Stonestreet Green Solar ISH 4 BESS

Oral representation on behalf of Aldington and Mersham Support Group

Drawing Title:
 Illustrative Battery
 Energy Storage System
 Detail

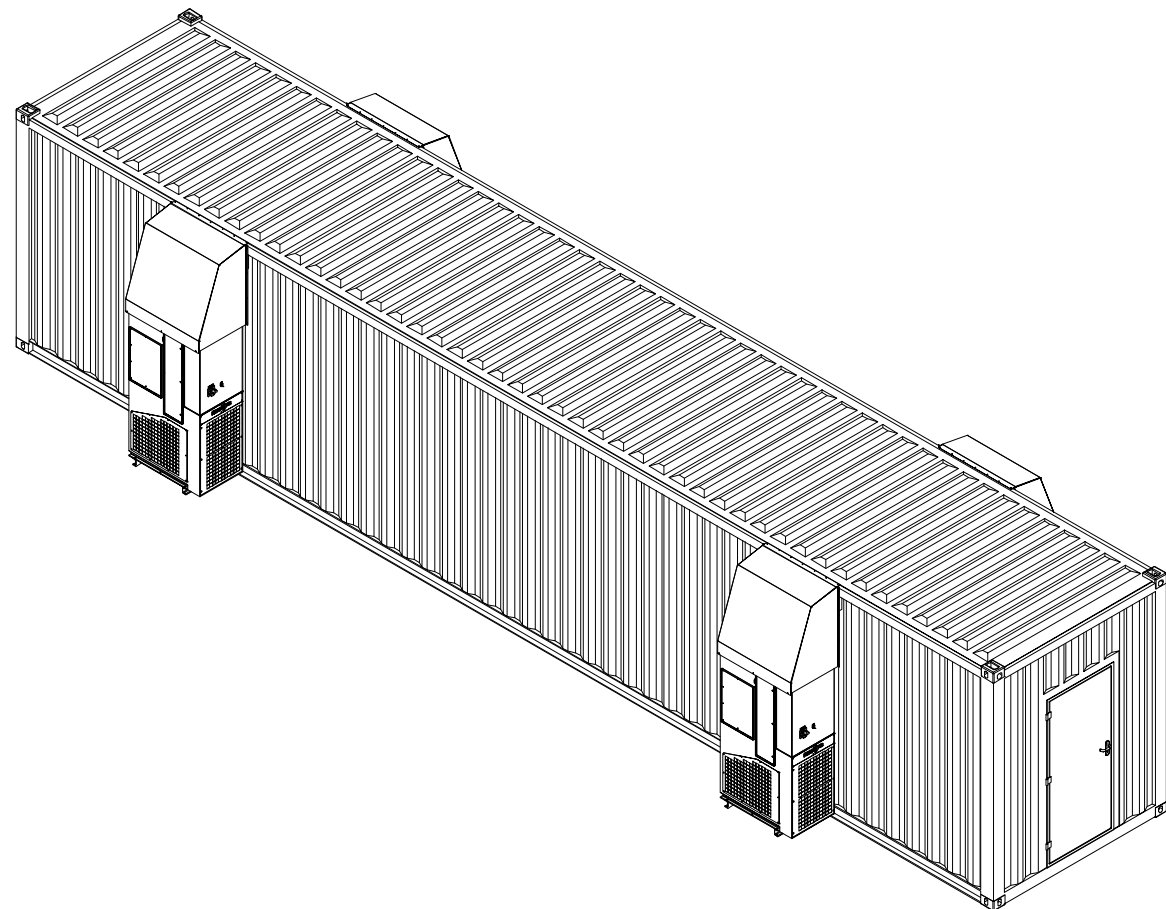
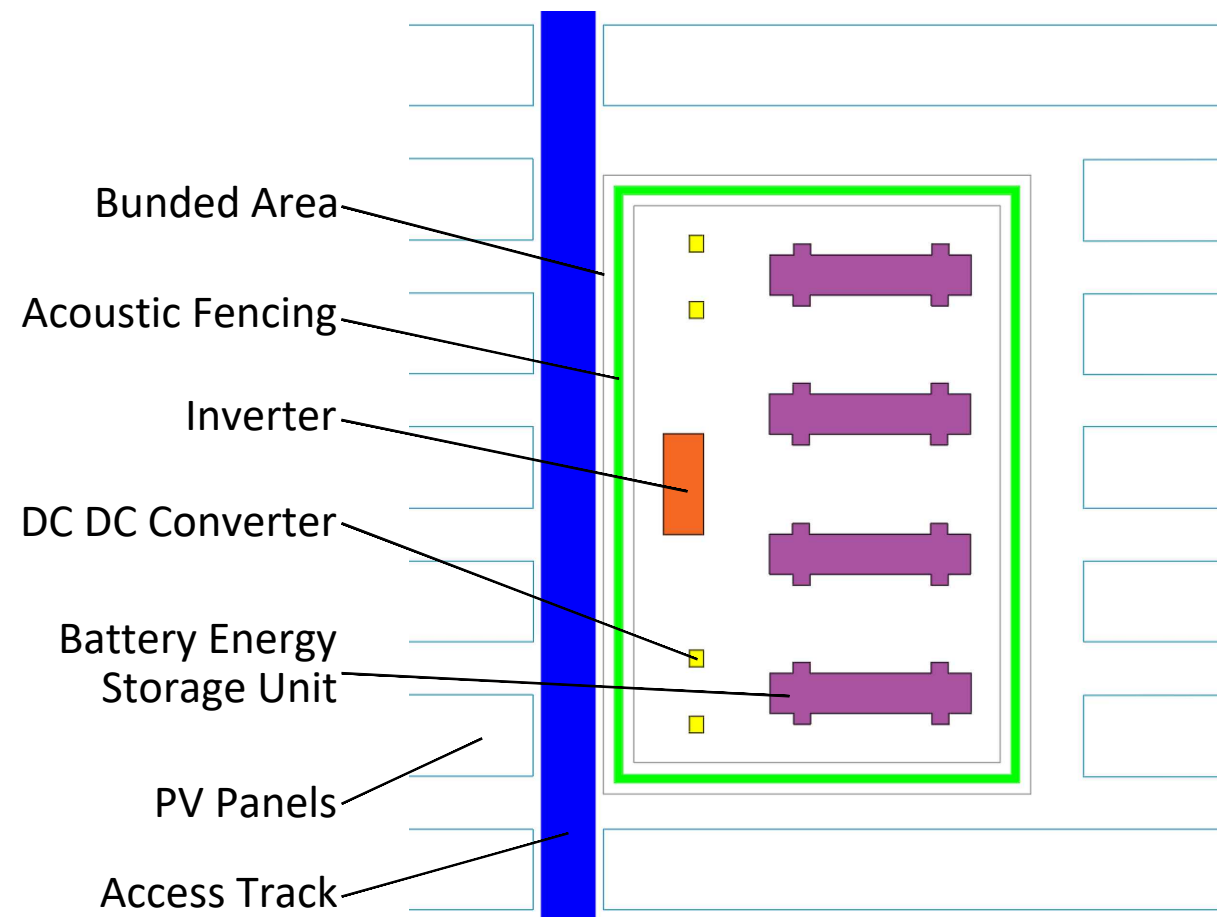
Whilst the generating output of the solar array has been clearly stated at 99.9 MW, the storage capacity of the BESS has never been revealed. In our Deadline 1 submission of December 2024 we estimate from flimsy information that it might be 232MWh in total. This figure has neither been denied nor confirmed by the applicant. It could be twice this size or more and so one of the largest in the world, which they deny. In the ISH4 the applicant was asked to state the size of the BESS in MWh. They were unable to answer but revealed that the BESS would deliver four hours of power. Taking this as the case suggests that the BESS is approximately 400MWh. The revelation of a BESS of 400MWh implies that it will indeed be larger than most in the world, larger than the Cleve Hill BESS at 300MWh and unusually large for a 99MW solar plant. This suggests that the main purpose of the BESS is not associated with energy balancing, smoothing etc for the local solar array, rather associated with energy trading and other purposes elsewhere. This energy level information is vitally important since the probability of a thermal runaway event increases in proportion to the number of individual batteries. Additionally, from direct experience of actual incidents the amount of cooling water and the time taken to burn out is dependent on the energy storage capacity of the BESS. In the circumstances of this particular application it is unreasonable and dangerous that a DCO should be granted without specifying the stored energy level in MWh.

As we have illustrated above the BESS design information provides a broad concept for the proposal but lacks key details as well as detailed information on essential points relevant to the actual location.
